In reply please quote: 22/10304

17 June 2022

**EIS ADVICE FOR SSD-36156297 DHL FACILITY (ASSOCIATED WITH SSD 5248 MOD 1) GAZECORP INDUSTRIAL ESTATE AT 813-913 WALLGROVE ROAD, HORSLEY PARK**

APPENDIX B – SITE PLANS

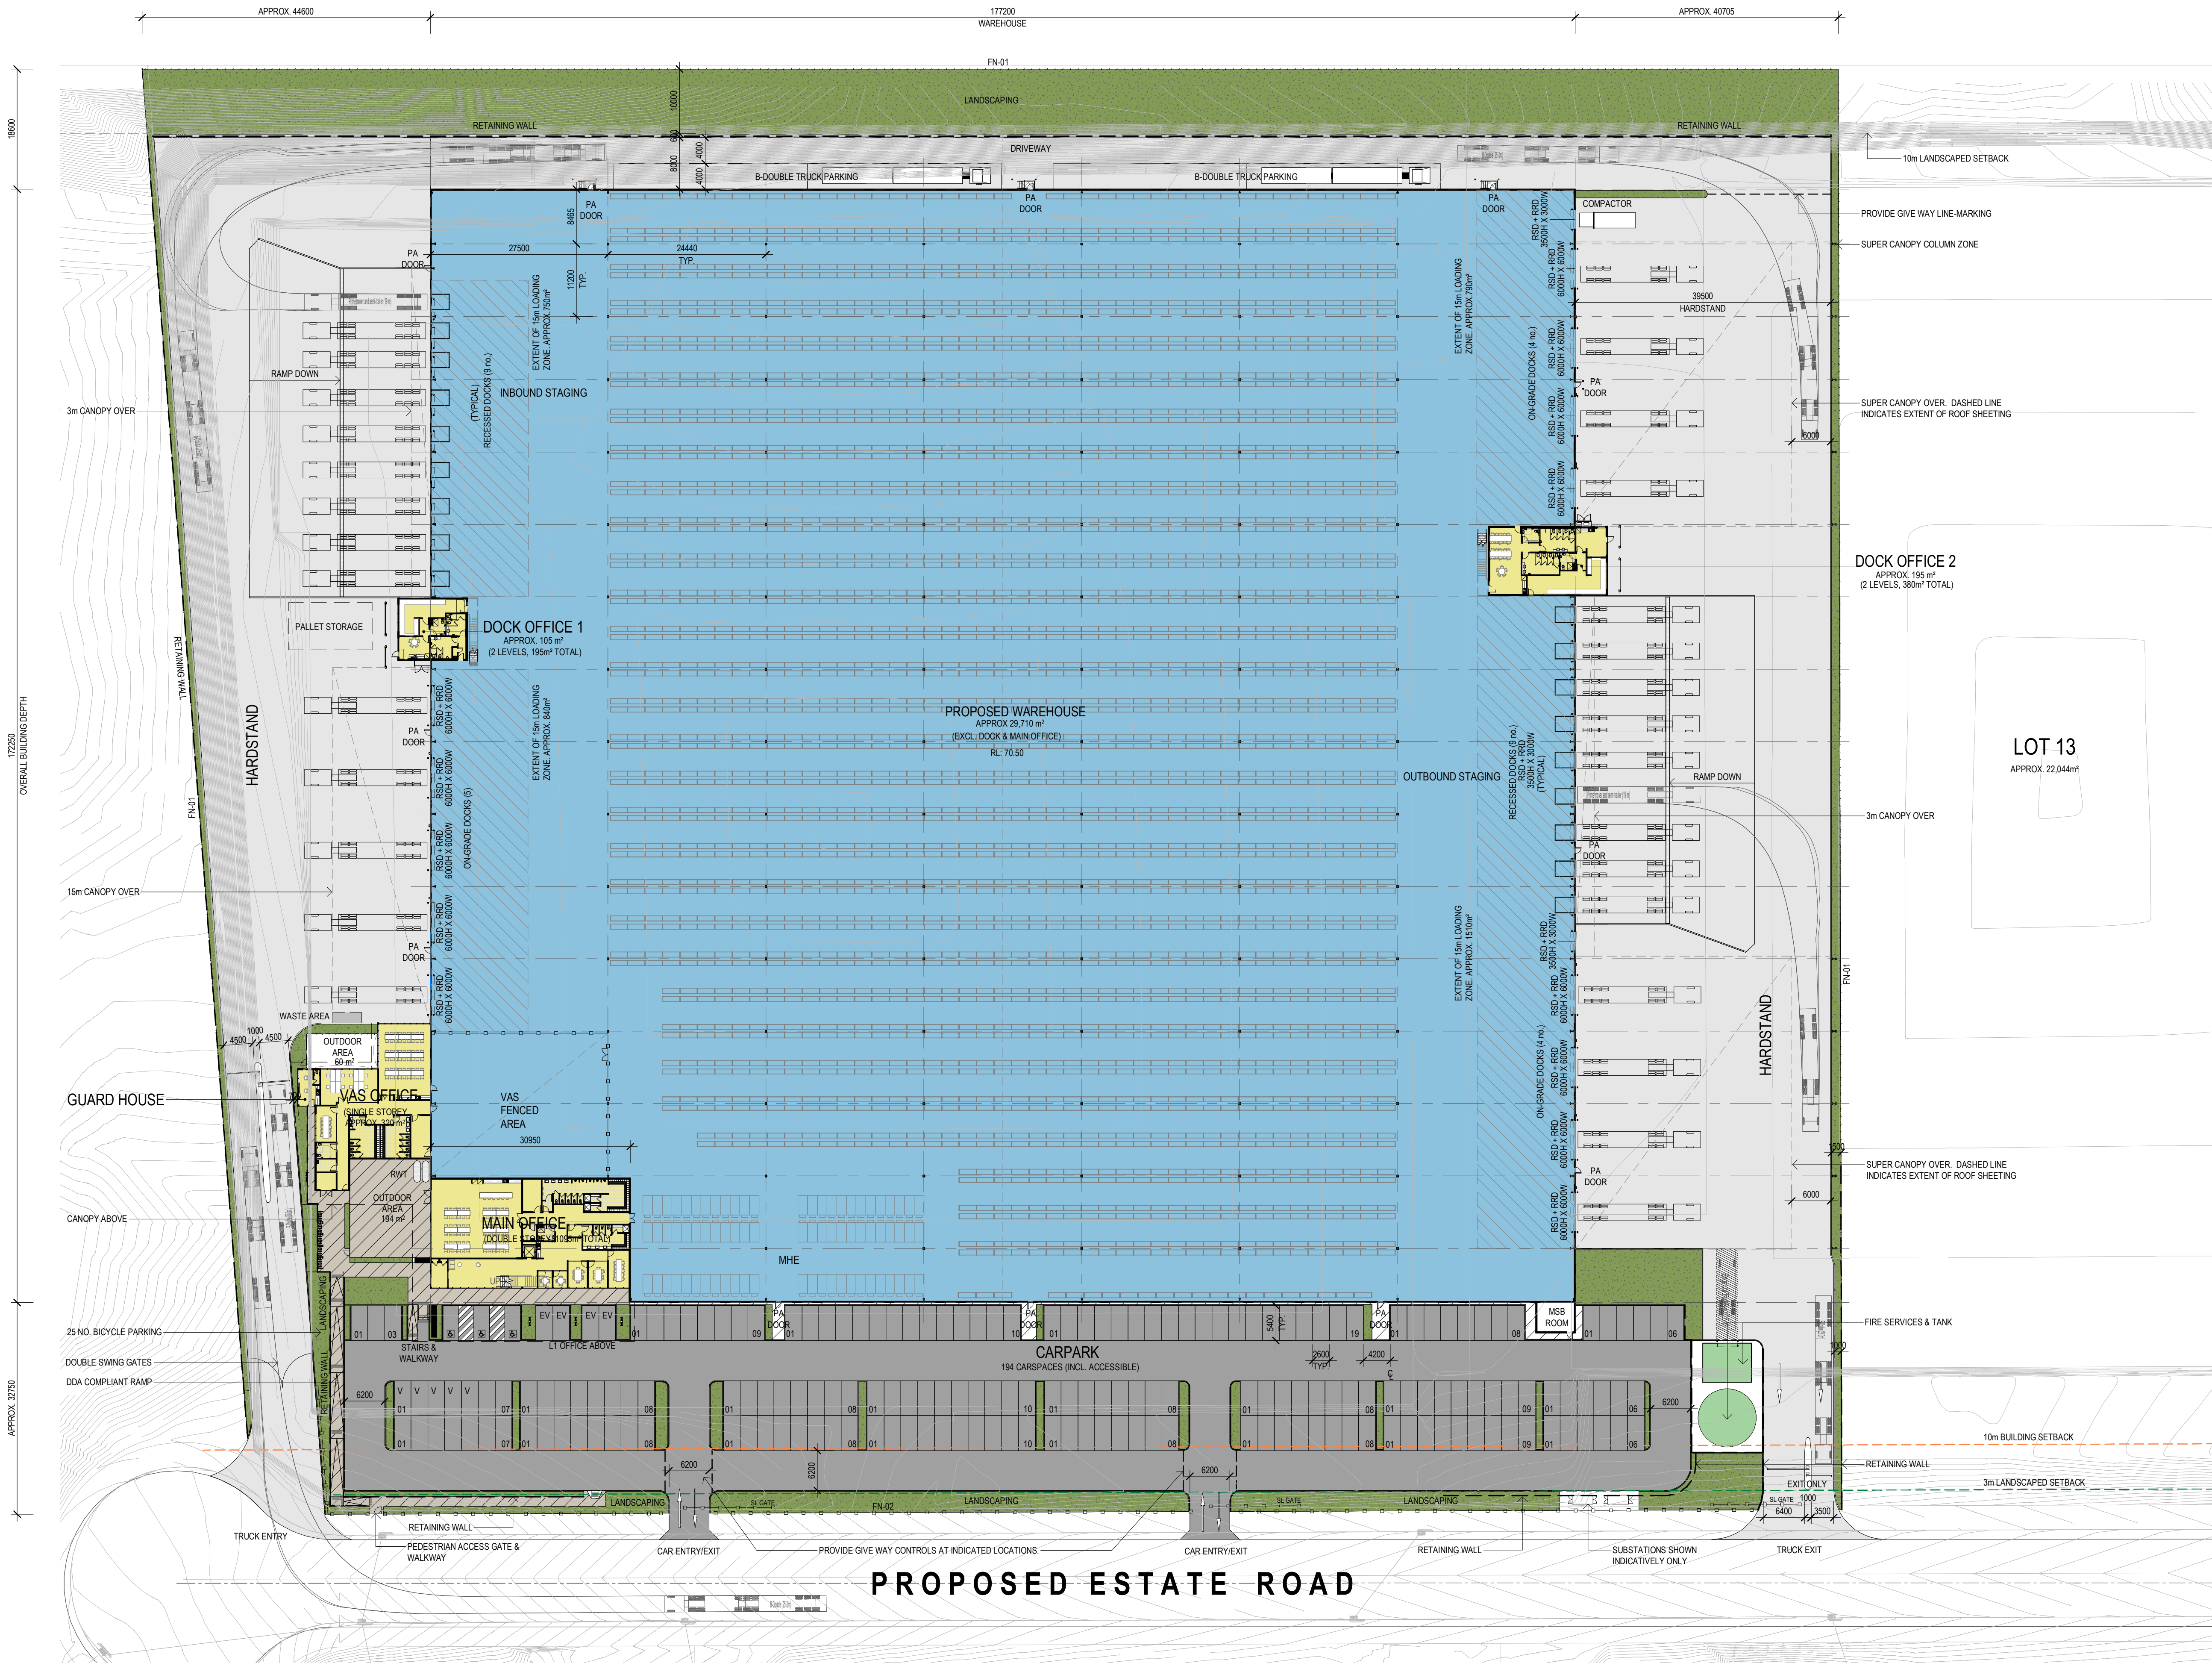
- The site does not make provision for a loading bay to accommodate 26m B-Double or 30m super B-Double vehicles. Clarification is required about where vehicles exceed 25m in length would park on-site to carry out loading and unloading activities. Service vehicles shall only carry out loading and unloading activities from the designated loading areas and shall not obstruct the flow of traffic within the site.

- Concern is raised regarding the site which allows B-Double vehicles parking close to the northern boundary of the site impacting vehicles manoeuvring within the site. There are risks with heavy vehicles colliding with the parked B-Double vehicles. The applicant shall submit further information to address this concern.
